Front Elevation
Scale: 1/4" = 1'0"

APPROVED
Limited building only review
Permit holder responsible for full compliance with the code

Plan# 2

# Foundation Plan

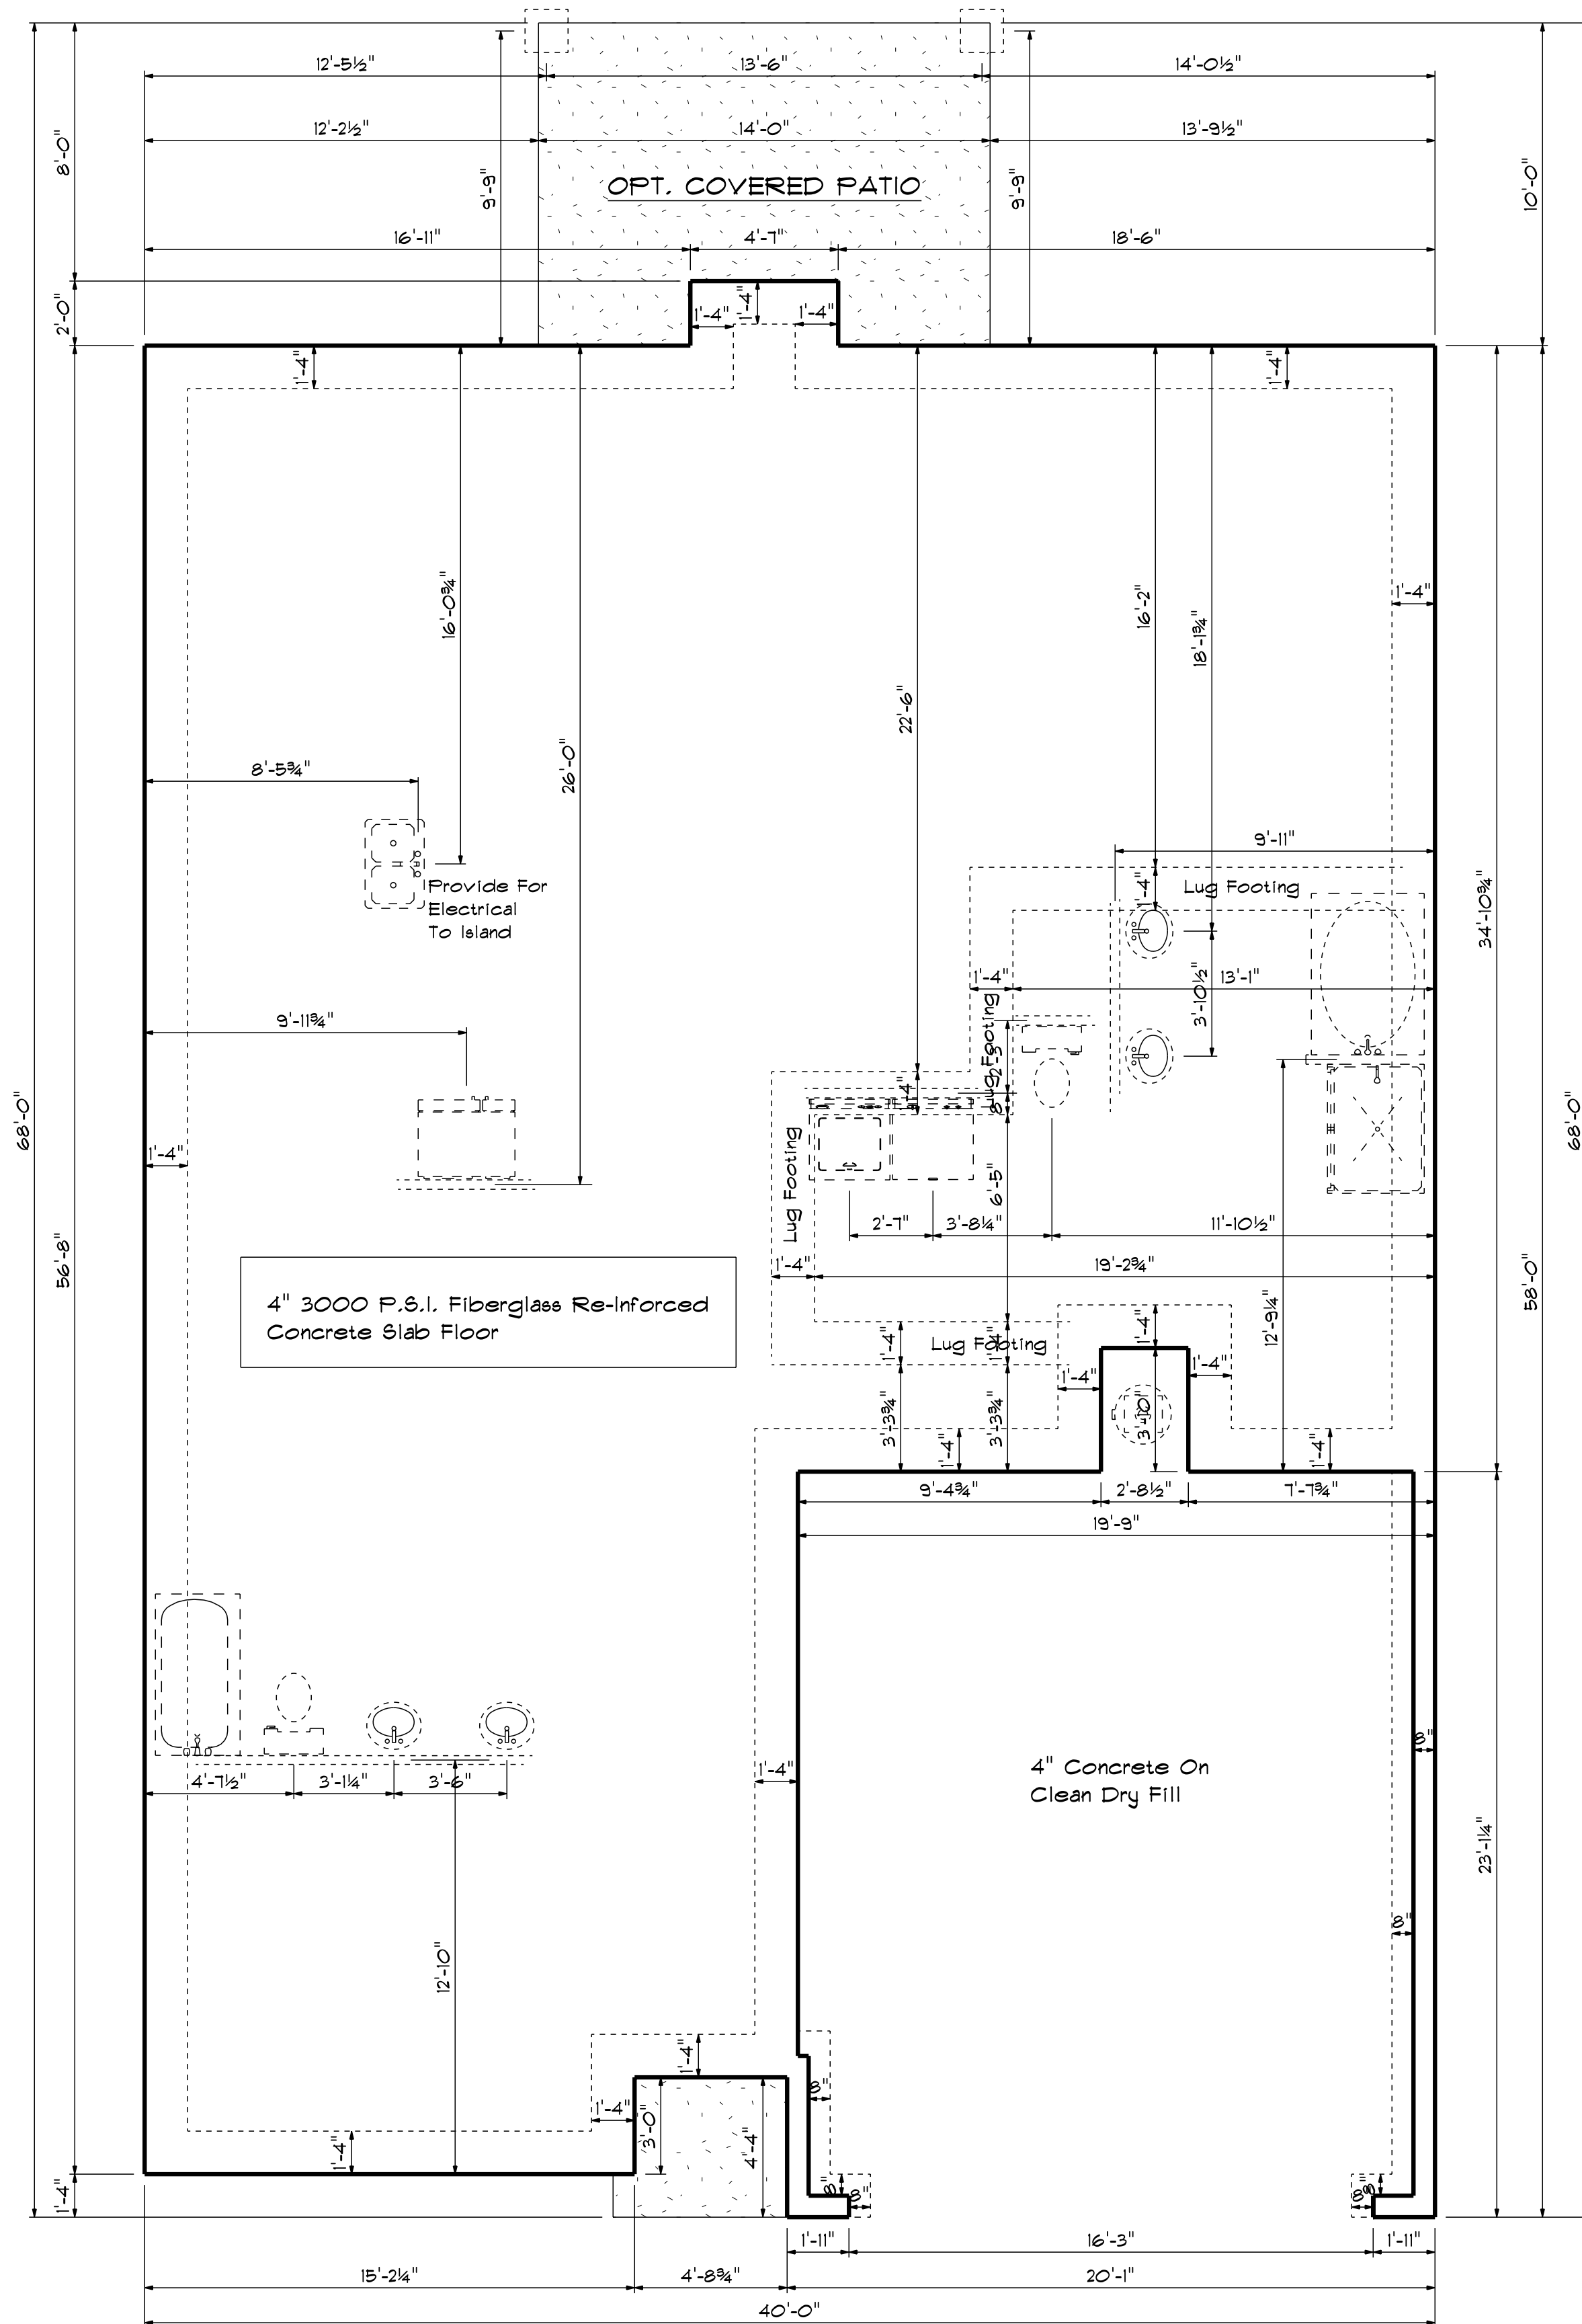
provide footings for B2GDR truss support
